**Consultation Response from KC,
Lead Local Flood Authority**

2026/90435 Land Off, Cockley Hill Lane, Kirkheaton, Huddersfield, HD5 0HH

Date Responded: 6th July 2026

Condition 18 – Flood Routing

TITLE	
PROPOSED BASIN DETAILS	
PROJECT	
COCKLEY HILL, KIRKHEATON	
CLIENT	
GLEESON HOMES	
DRAWING STATUS	
PRELIMINARY	
Scale	Date
AS SHOWN @ A1	NOV 25
Drawn	IC
Chk.	MI
Org. No.	Rev
2181/07/13.01	A

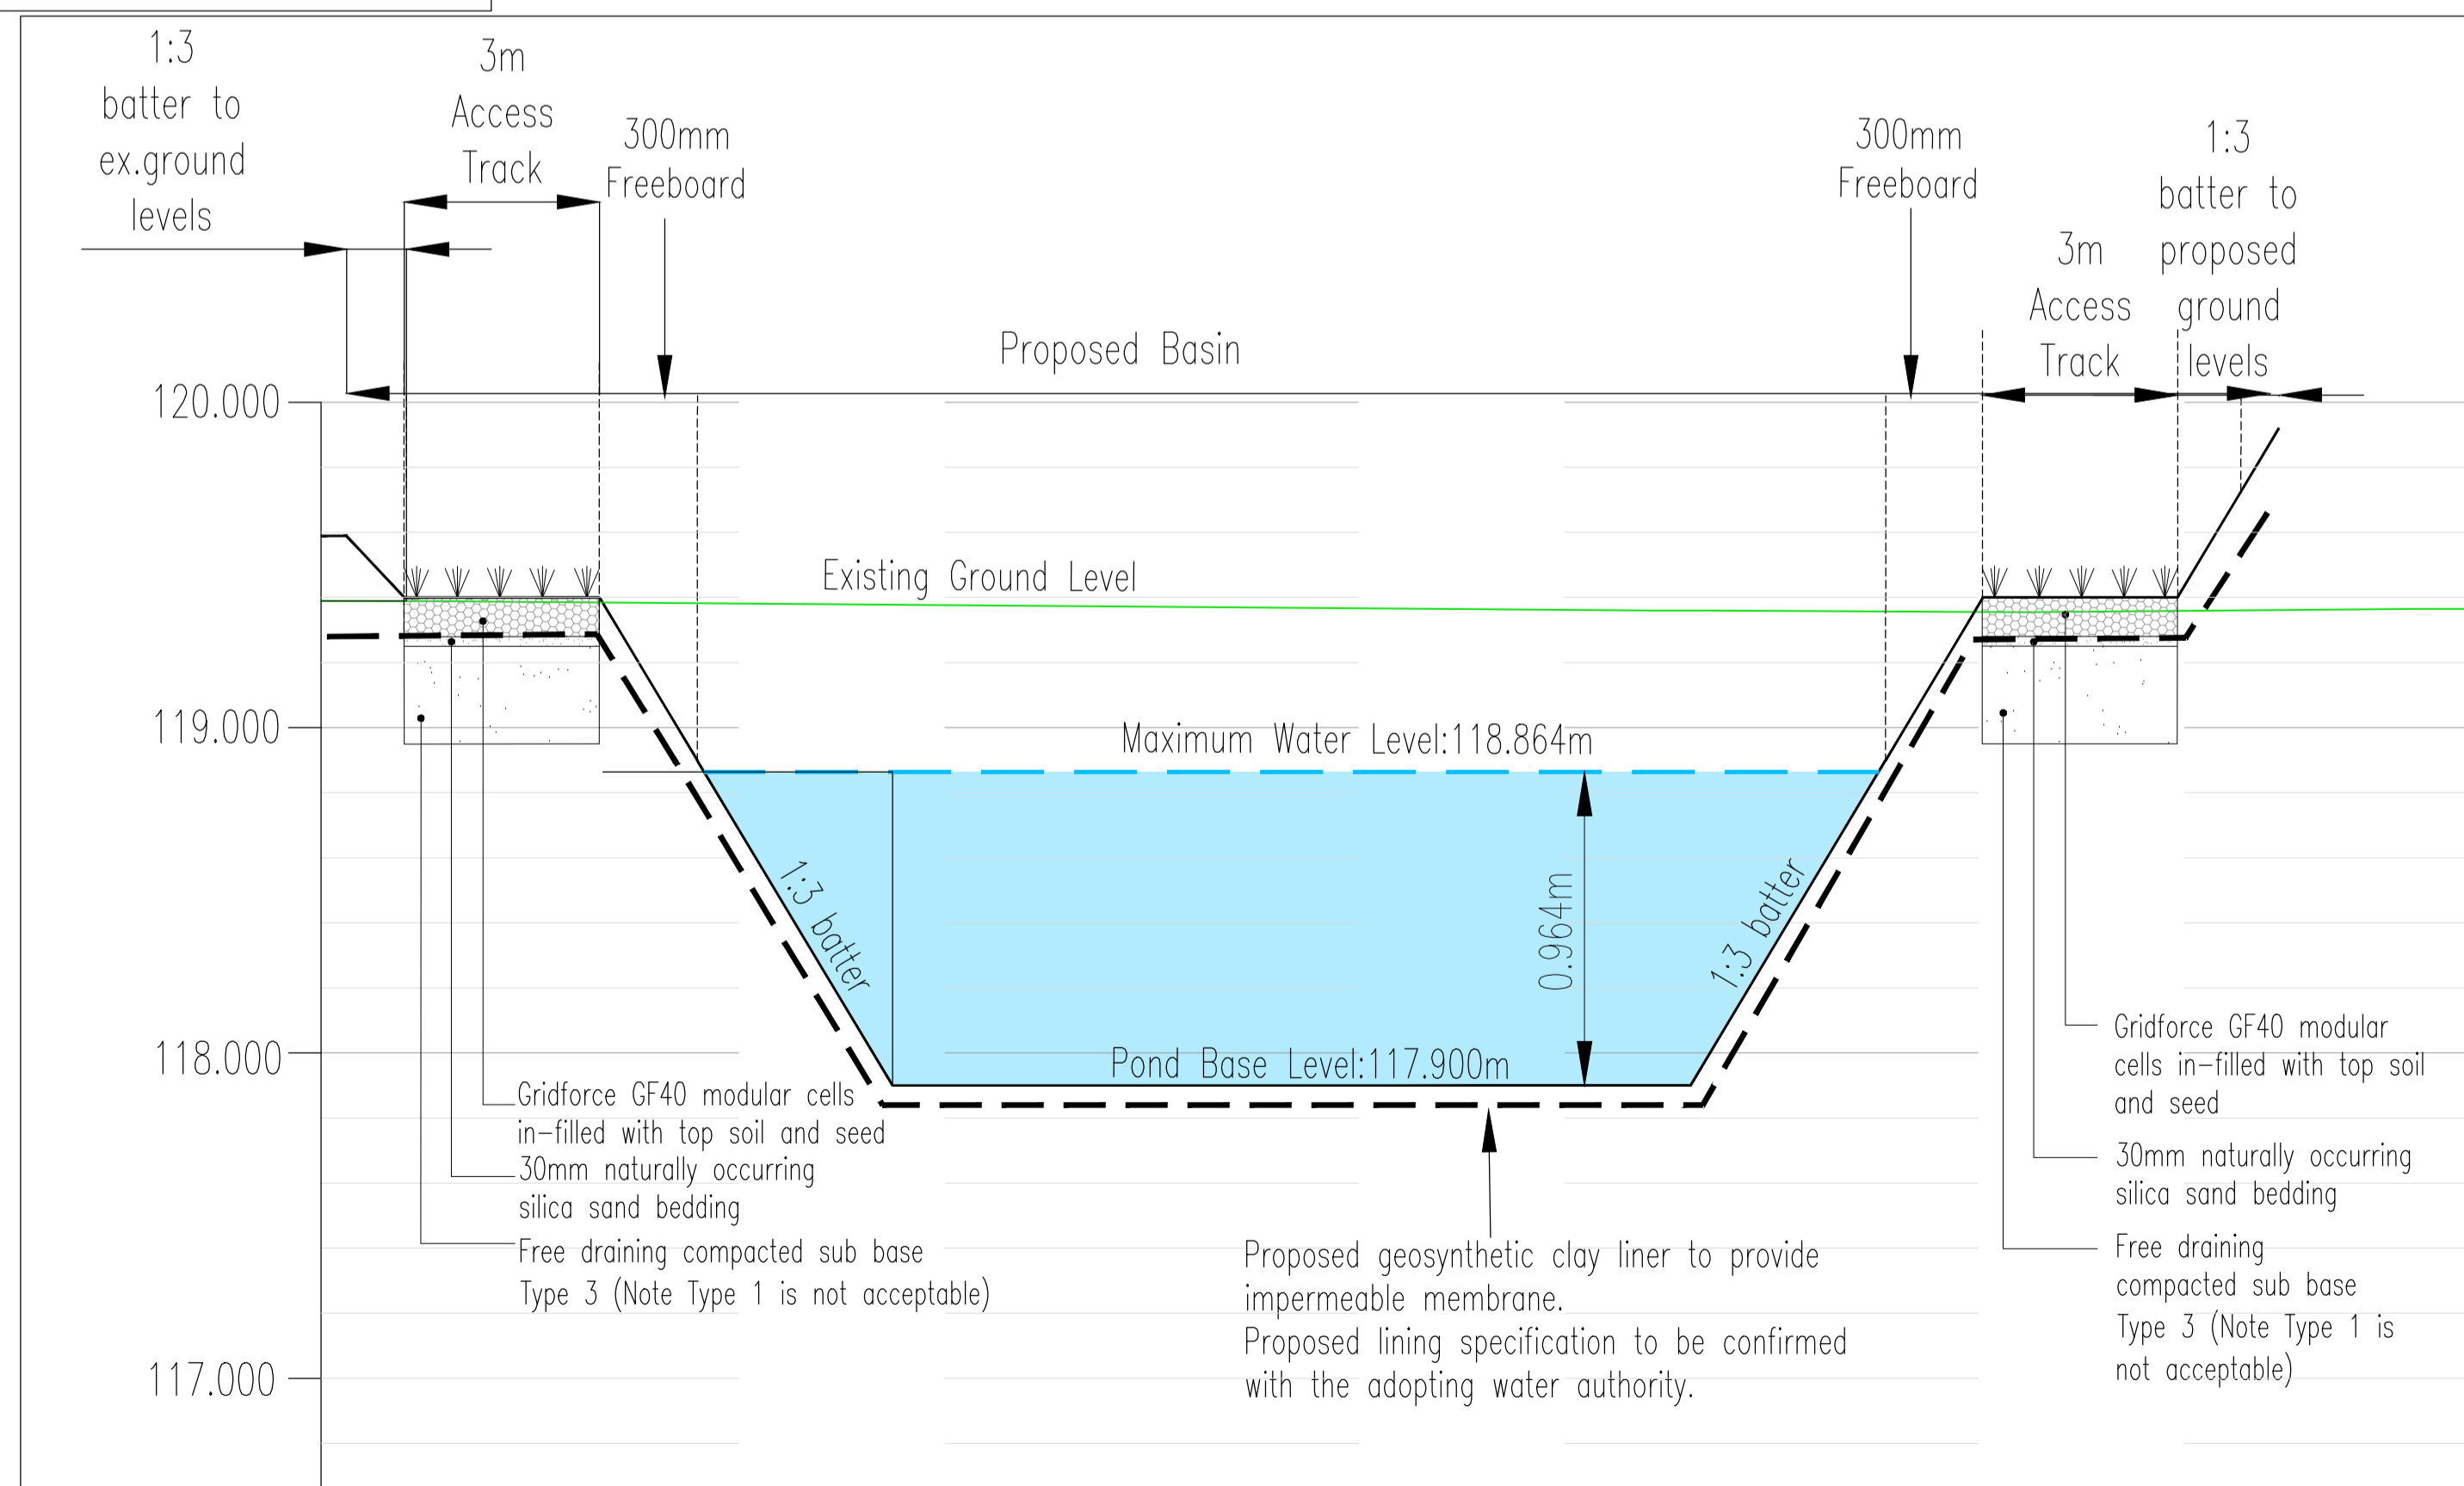
A lowering of the detention basin bank by 50mm to create an overspill on the western side is noted. This must be replicated on all drawings that show that attenuation feature so is it not missed in construction.

A land drain is noted under the embankment sill point. We note that the ground levels fall toward existing housing, so a detail showing the land drain and how excess water will be picked up is required. Currently, overland flow will occur with notable risk. We suggest an addition such as a reverse soakaway with a geotextile membrane on the outer ring and backfilled with clean stone (large size) up to 18 inches from the top and to be wrapped in the geotextile. The remaining level can be more decorative/functional gravel to the surface, around the manhole cover. This ensures a porous surface for the water to efficiently enter the land drain. Cross sections of this or an alternative solution is required.
